Your Ref: OWQC18923
Our Ref: R/105/18/PL
Please ask for:
Mr A Wood

Change of use of integral garage to form treatment/waiting room, 2 No. dormers to first floor front extension, replacement of rear dormer with 1 No. velux window, balcony to side, change of side window to window & door & 1 No. additional velux to ensuite (amendment to R/45/17/PL).

Sandon The Coppice Rustington

Thank you for your internet comments made on 19th June 2018 which has been recorded as **'an objection'** with the comments as follows:

PROPOSED GROUND FLOOR PLAN

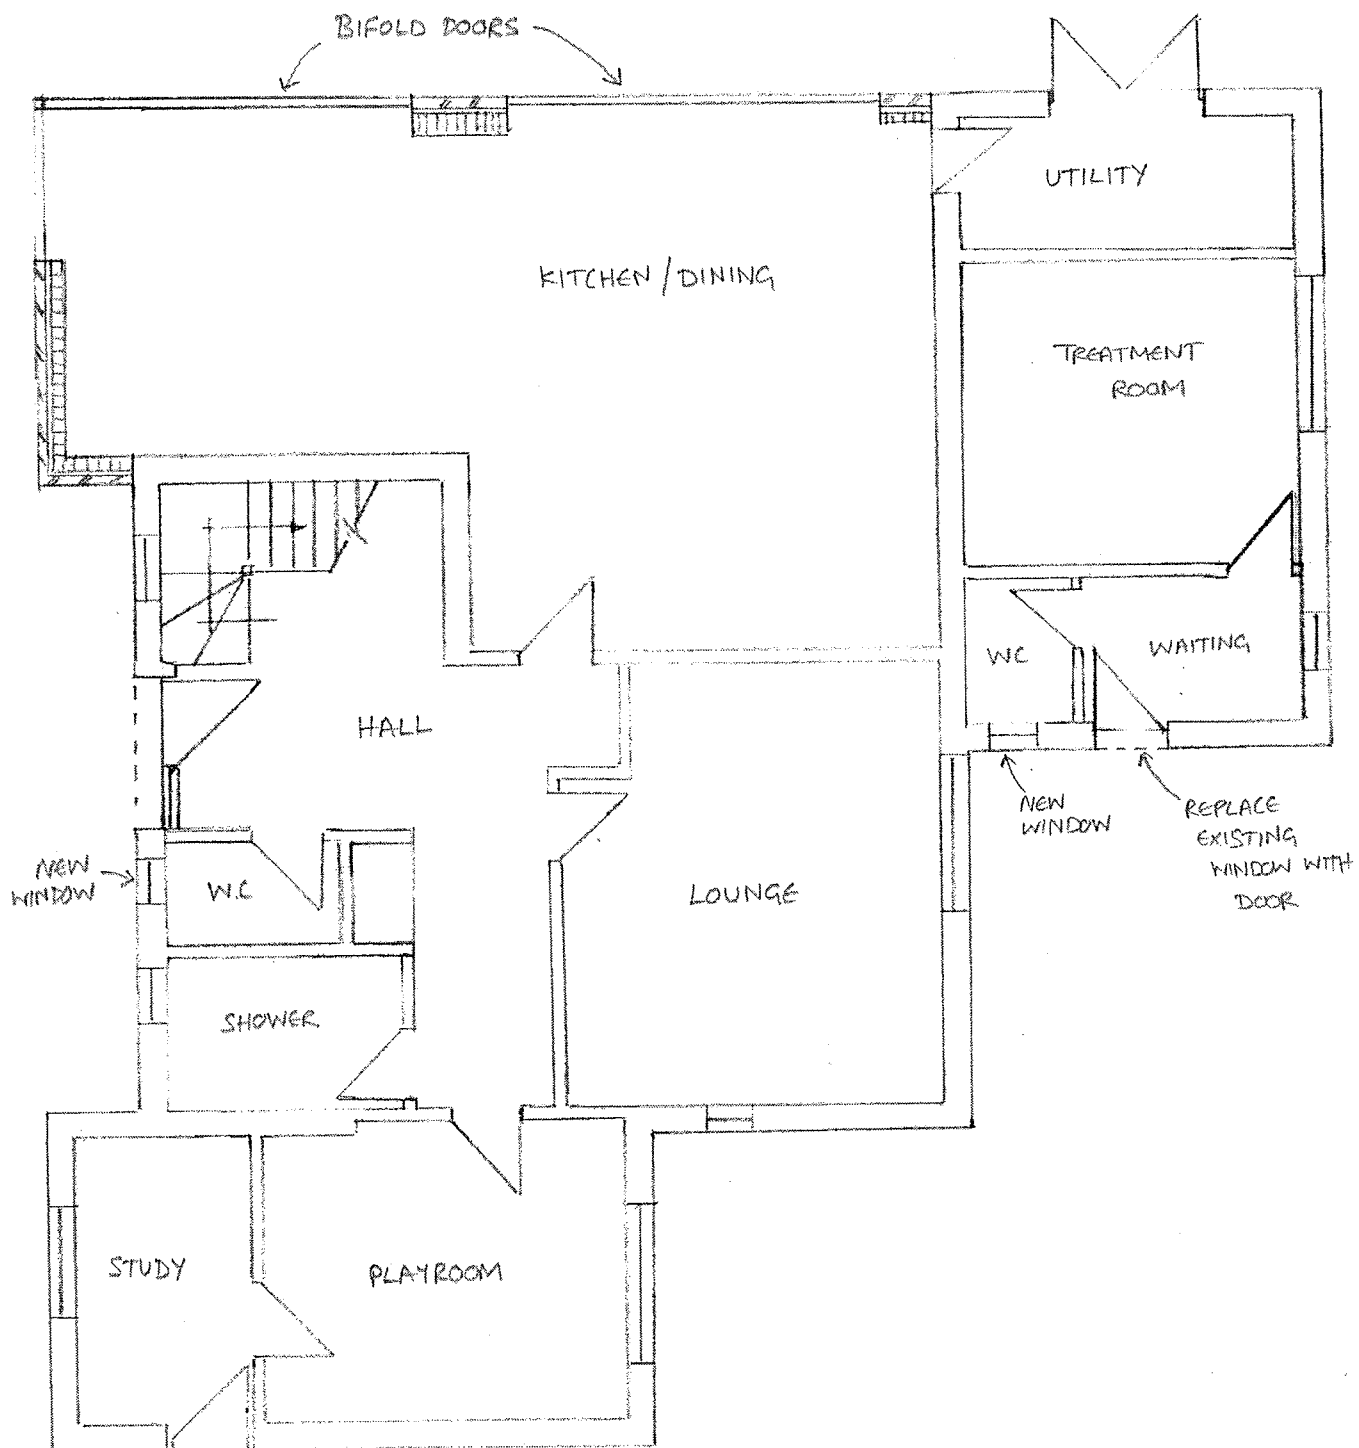
(iii) The proposal, in particular respect of the change of use of a garage into a treatment room and waiting room, for a business purpose, could result in an increase in the number of standing vehicles in both The Coppice, a very narrow cul-de-sac, and Herne Lane, in close proximity to The Coppice Surgery, which would add to the hazards of road users in this vicinity.
